Eve Hearsey

From: Christopher Hobden [REDACTED]
Sent: 30 December 2010 07:46
To: [REDACTED]
Cc: Eve Hearsey
Subject: RE: Soldiers Field Stables Findon FN 83/10

Application No. FN/83/10

RE: SOLDIERS FIELD STABLES, SOLDIERS FIELD LANE, FINDON, BN14 0SG. REGENERATION OF DILAPADATED STABLE YARD AND ASSOCIATED BUILDINGS COMPRISING 3 NO. HOLIDAY COTTAGES AS A NEW RESIDENTIAL DWELLING (WITH REPLACEMENT DWELLING AND ANCILLARY STABLE YARD AND STORAGE BARN AS PREVIOUSLY PERMITTED UNDER FN/37/09) WITH REVISED VEHICULAR ACCESS ARRANGEMENTS.

Rev	Date	Description	By
Scale 1:100 @ A3			
Date Nov 2010			
Drawn GM			
Drawing Number 10/157/Sk03

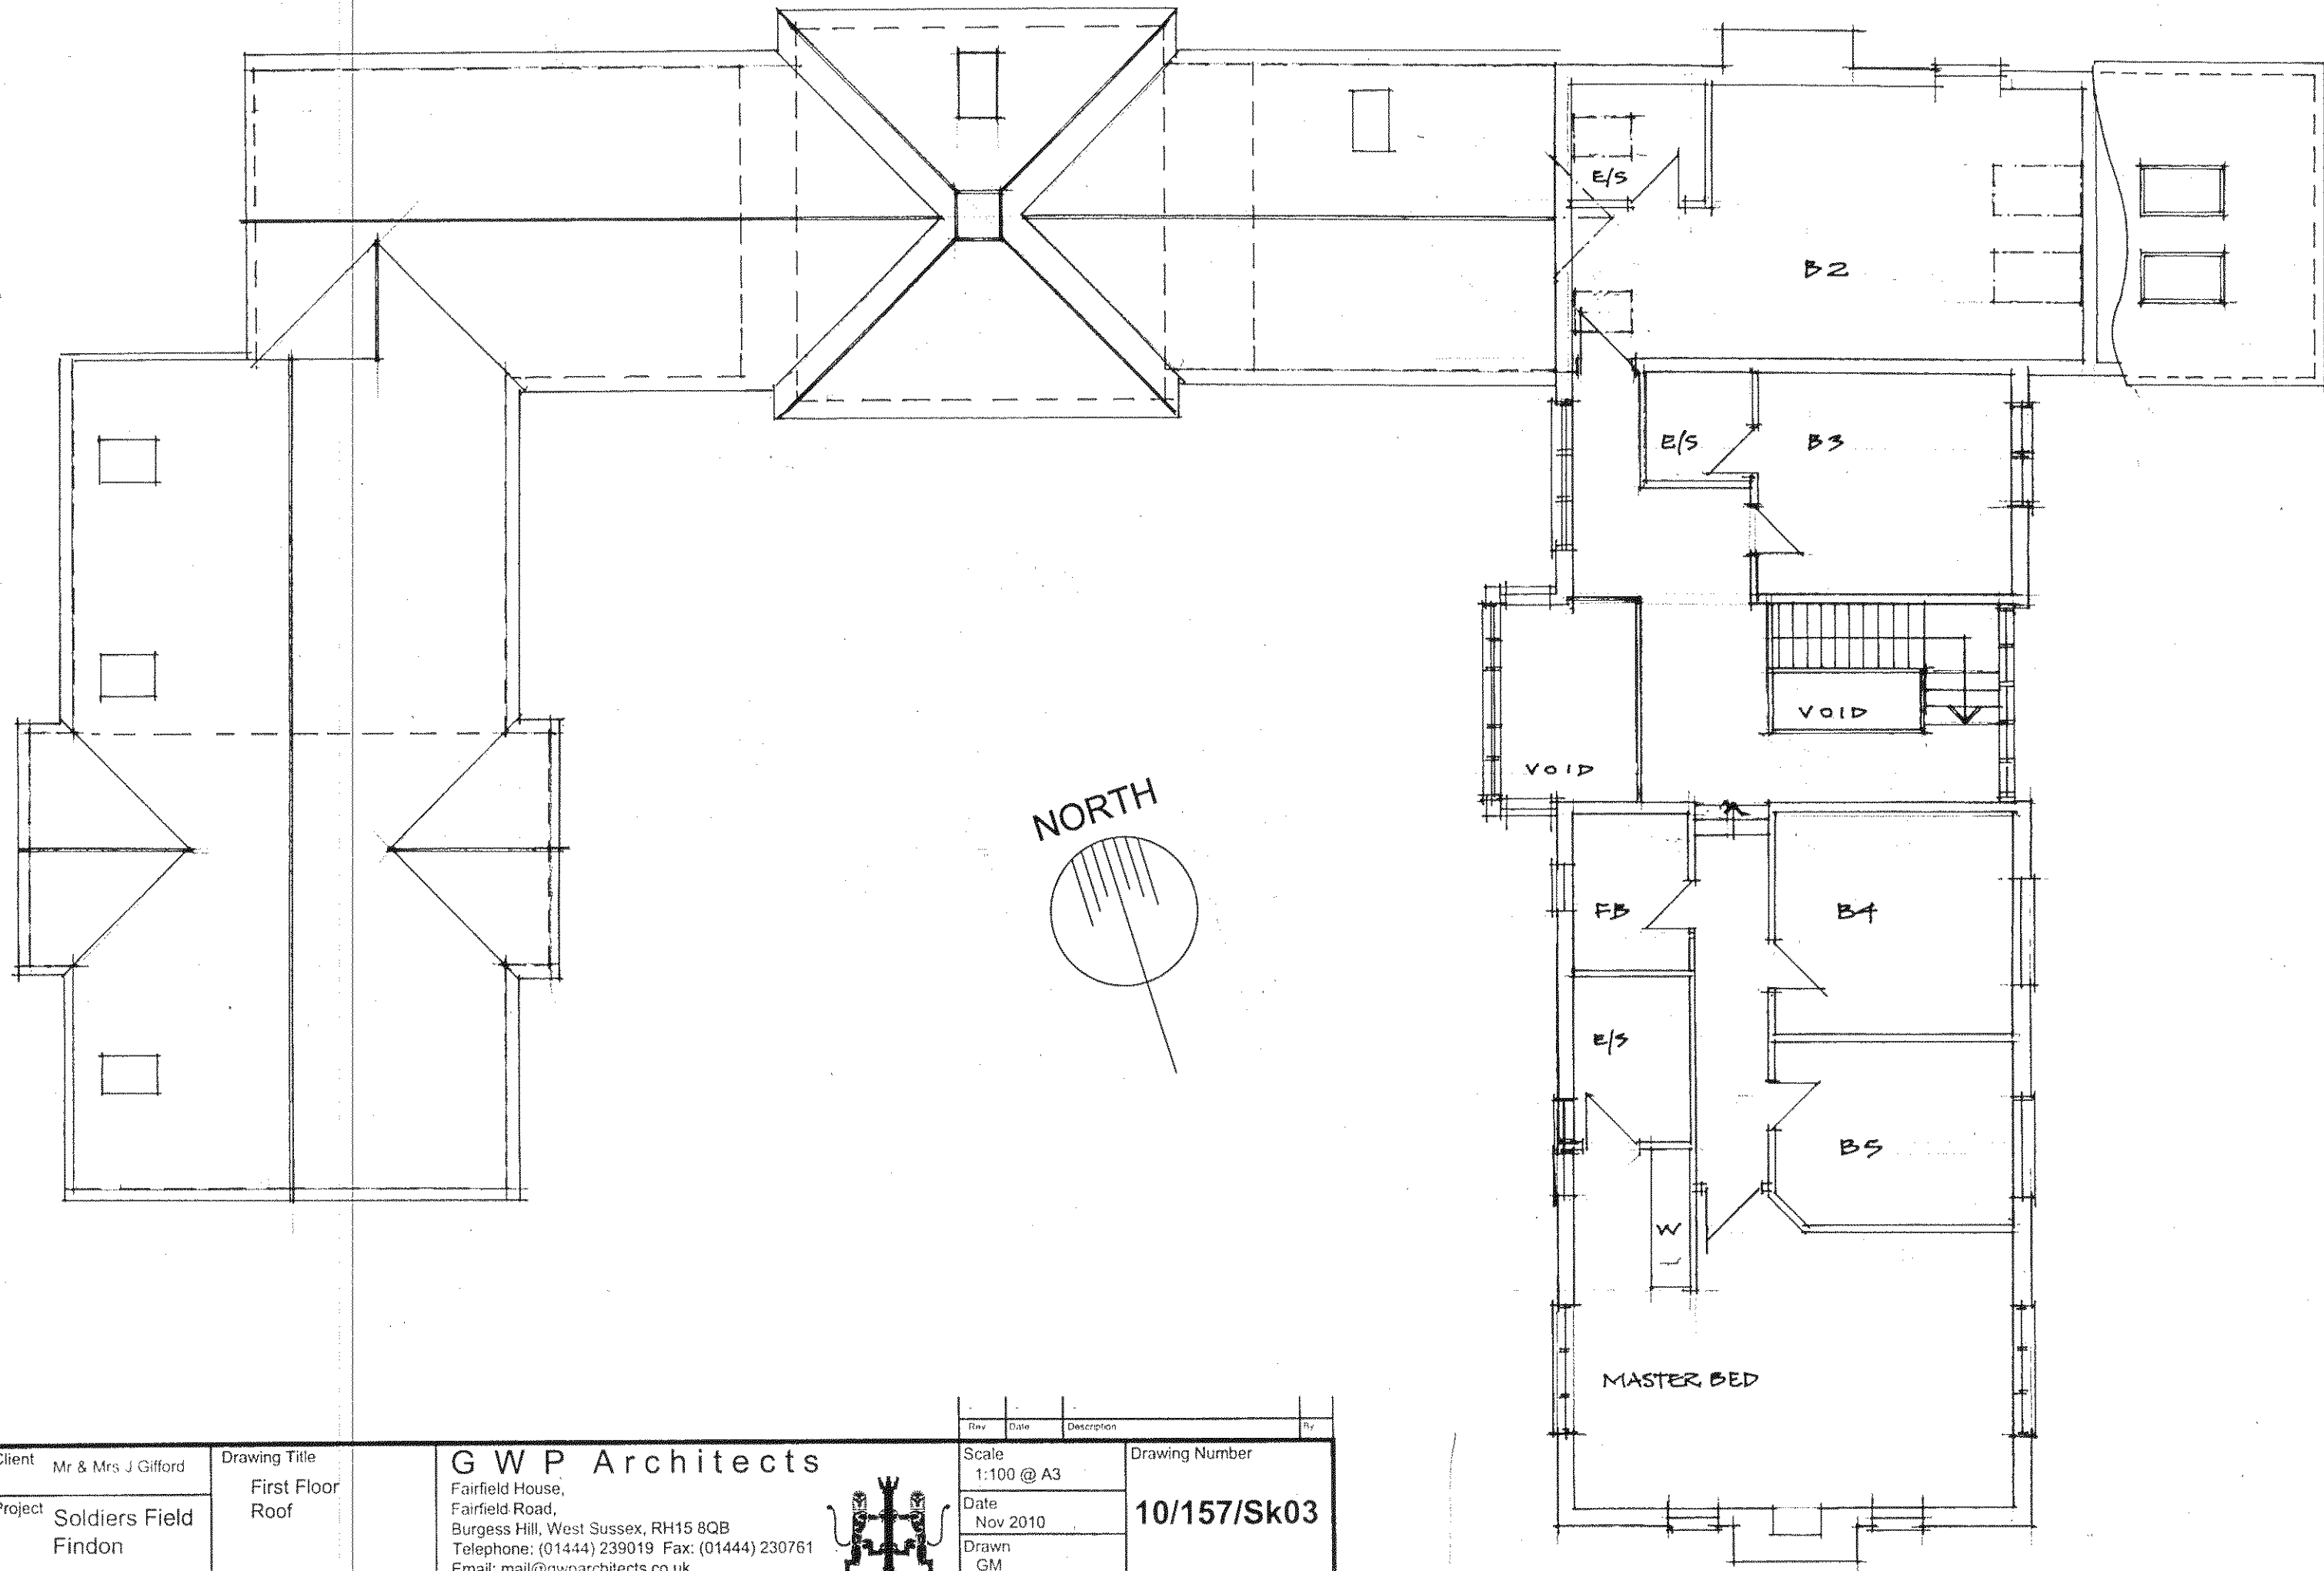
1. Drawing No.10/157/Sk03 shows 2 windows at first floor level in the southern gable end wall. These windows directly overlook our property, whereas in the planning consent already granted FN 37/09 there are no directly overlooking windows.

I refer to our telephone conversation earlier this week and attach as promised 3 copies of my main amended drawings numbered 10/157 sk01A, sk02, sk03A, sk04, sk05A, sk06A & 10/157 Loc A. As discussed these drawings incorporate certain minor amendments as advised to you following consultation with Mr & Mrs Hobden who own the property immediately to the south of the application site. These amendments include modification to the roof of the detached garage building to incorporate a hipped gable to the south elevation and the omission of 2 No. south facing windows to the proposed master bedroom at first floor level.

I have already agreed with Ms Hearsey that in accordance with neighbouring owner's comments the Applicant will remove two south facing first floor bedroom windows from the main house and modify the proposed garage roof to incorporate a hip to the south pitch.

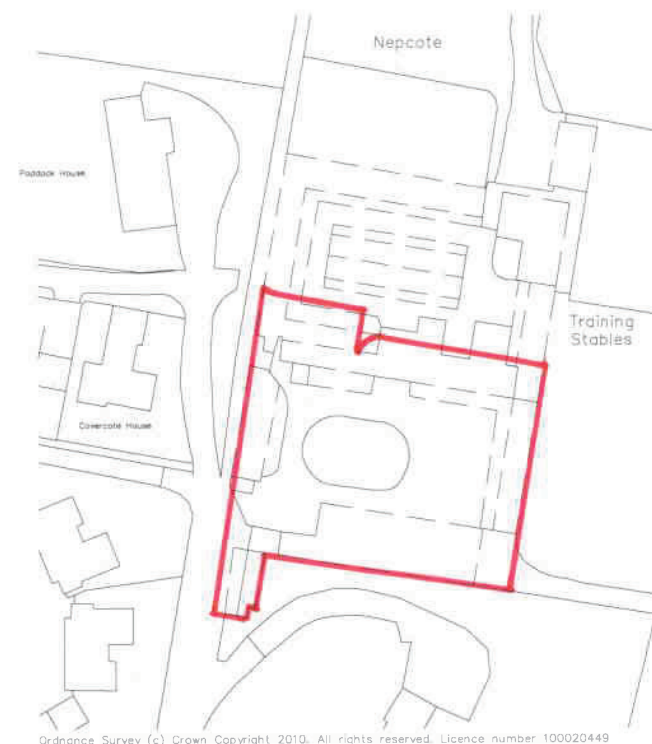
3. FN 37/09 has the Bin Store building to the south of the main entrance. FN 83/10 (Drawing No.10/157/Loc) does not replicate this but shows the existing single storey building in that location demolished. Again the rear wall of this existing building defines the boundary between your client's property and ours and if it is to be demolished, please specify the design treatment you propose for the new boundary fence or wall.

We have also discussed the potential to condition certain boundary treatment details.

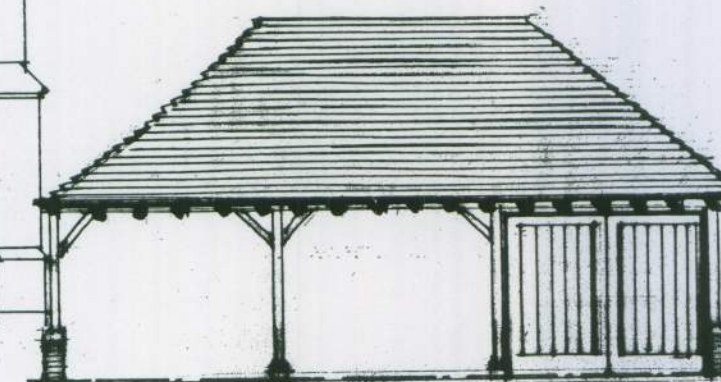
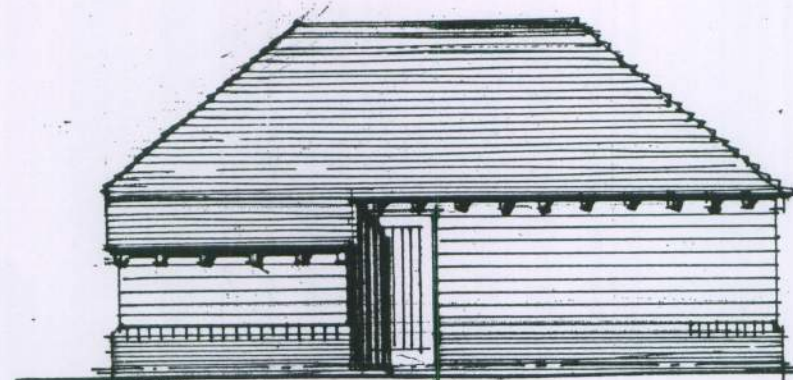
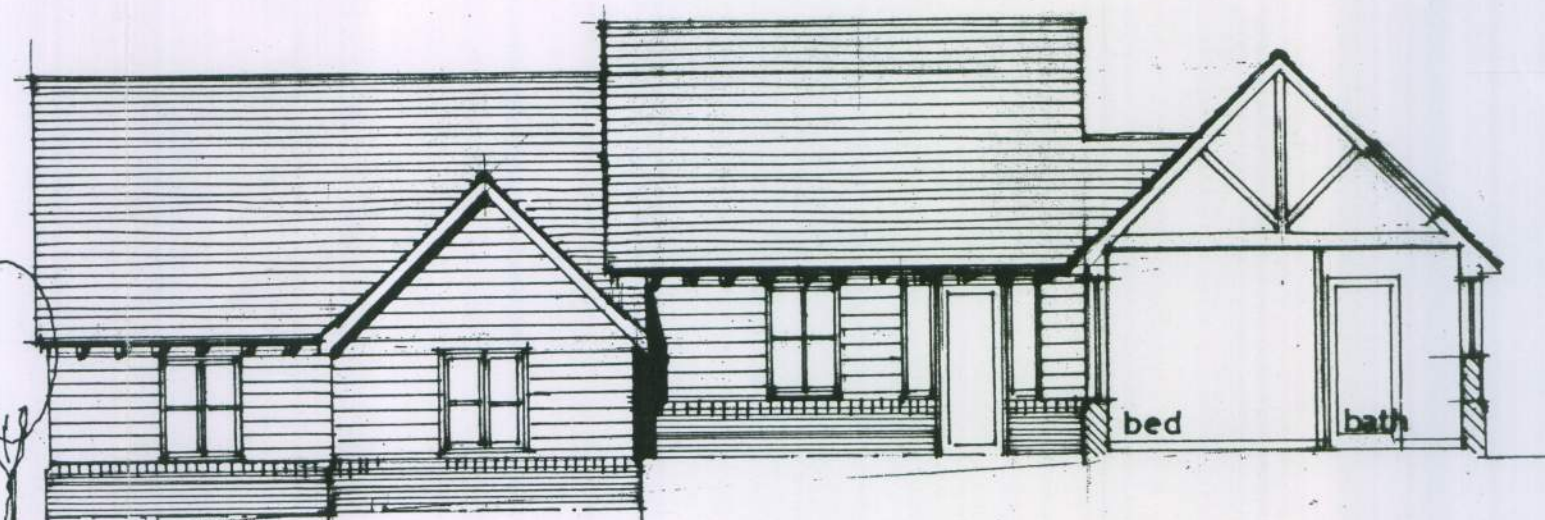
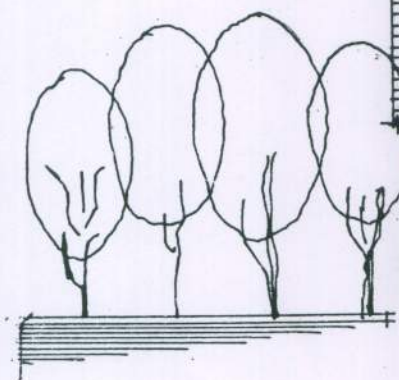
I forgot to mention one further point which we noticed on the plans. Drawing 10/157/Sk06 has the proposed garage on our boundary, which is fine, but we request that the pitched roof is hipped at the South end (to match North end) as this will reduce the height and visual impact of the new building on our boundary.
